West Coast Sea Products Ltd
Dee Walk
Kirkcudbright
DG6 4DQ
01557 330789

Interested Party Reference number: 20047994

1. Summary

Figure 1.3: Indicative location of Scallop Mitigation Zone.

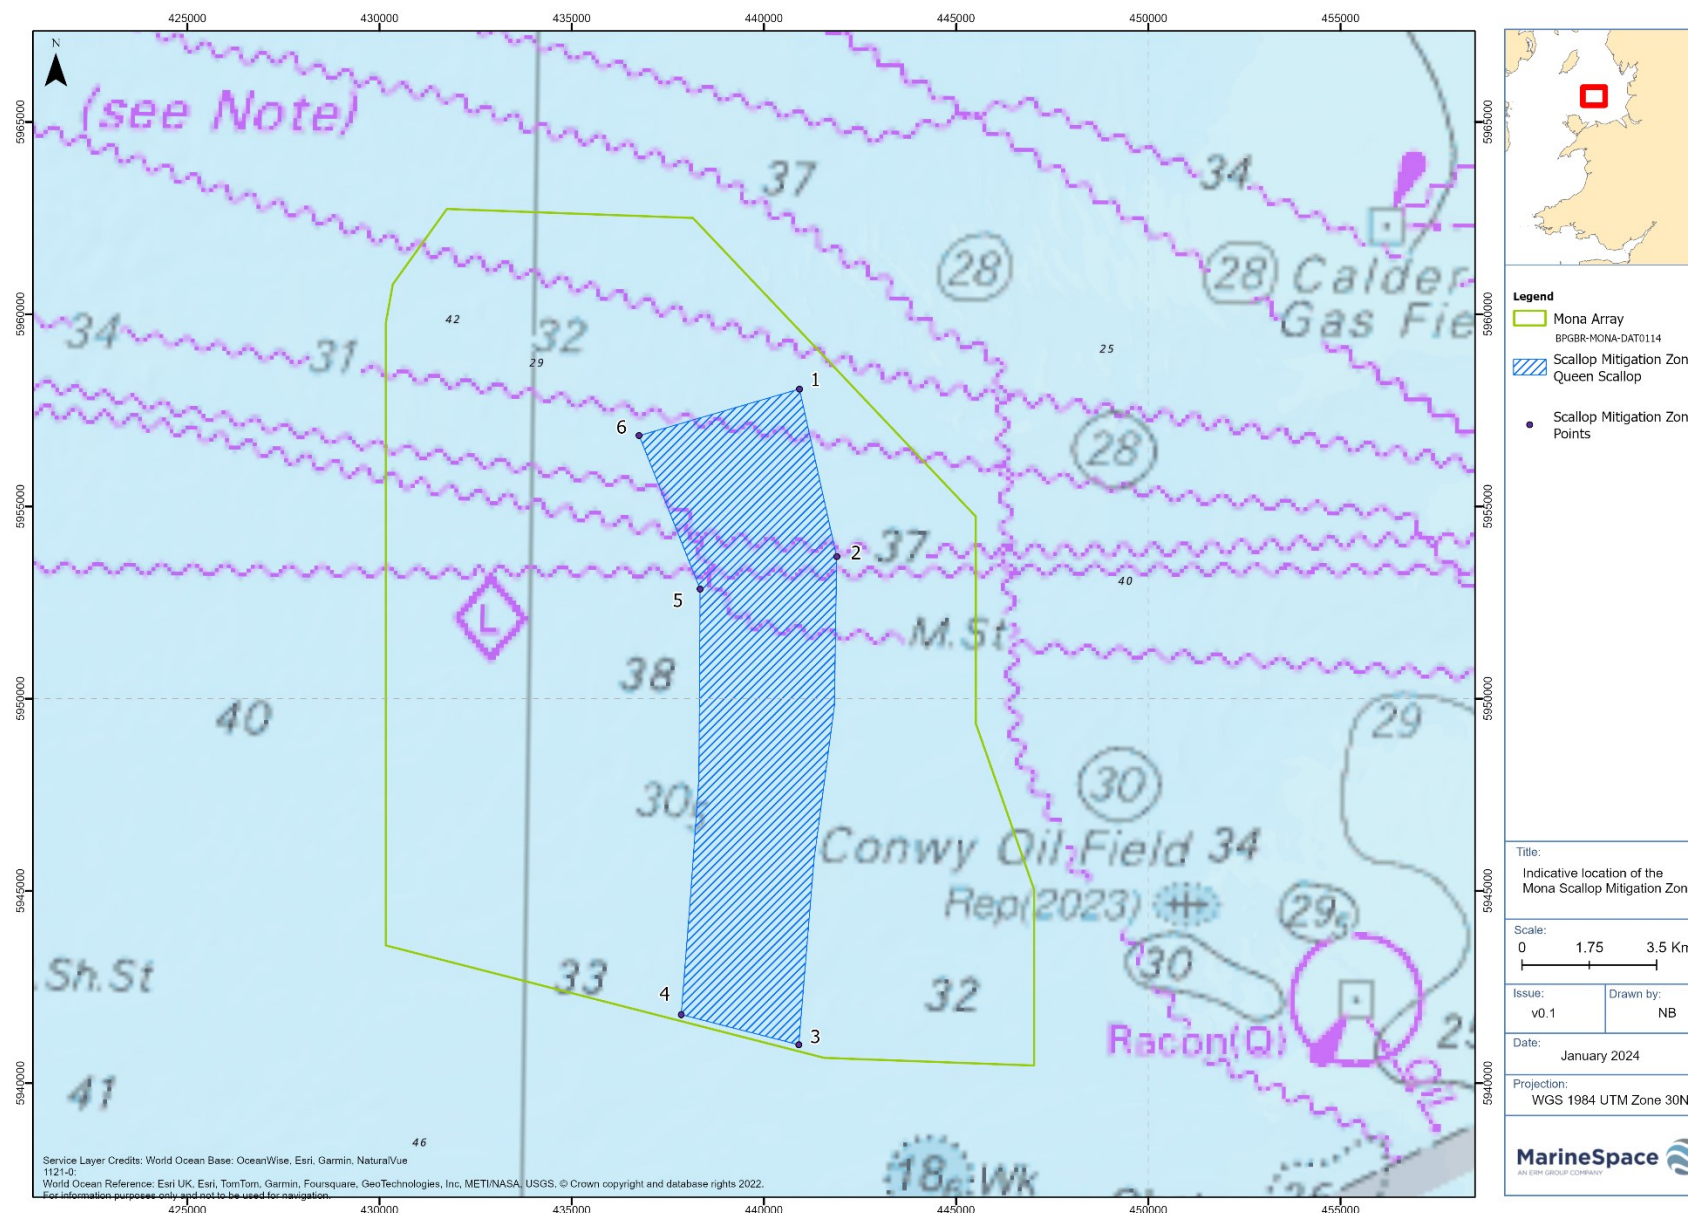
The final flaw of the coexistence plan concerns the fundamental Scallop Mitigation Zone which is based upon us providing coordinates to the applicant (Figure 1.56, Doc reference F6.6.1). It is noted that the Scallop Mitigation Zone corridor as it stands is some 3.2km in width, however is only some 35% of what we communicated to the applicant (i.e. Figure 1.56, F6.6.1). If Figure 1.56 of Doc reference F6.6.1, was presented as the Scallop Mitigation Zone within Mona with a 5-6km corridor, we would perceive this as more proactive level of coexistence. Our understanding of the current proposal is that true coexistence and the Scallop Mitigation Zone has been tightened as a consequence of the developer choosing not to utilize the eastern extents of the original lease area due to poorer wind yields. This is a disappointing justification given that there are windfarms to the east of Mona in operation and should the applicant have developed to the east, would not have

encroached upon valuable fishing ground. Also essentially, Section 1.3.6.1 also suggests that the Scallop Mitigation Zone will be a let down to Queen Scallop fishing vessels such as ourselves as it (a) states that the Scallop Mitigation Zone will be further refined and (b) suggests that cables will likely run through the Scallop Mitigation Zone.

- A deeper cable burial target than 0.5m,
- Widen the Scallop Mitigation Zone by some 1-2km since the current Scallop Mitigation Zone is disappointingly not wide enough and only a portion of what was communicated as the most prominent fishing grounds for Queen Scallops. The document suggests the Scallop Mitigation Zone is indicative and will be refined which makes us further cautious about what the end result shall be. There needs to be a real commitment in this regard
- A commitment to not take cables through the Scallop Mitigation Zone.
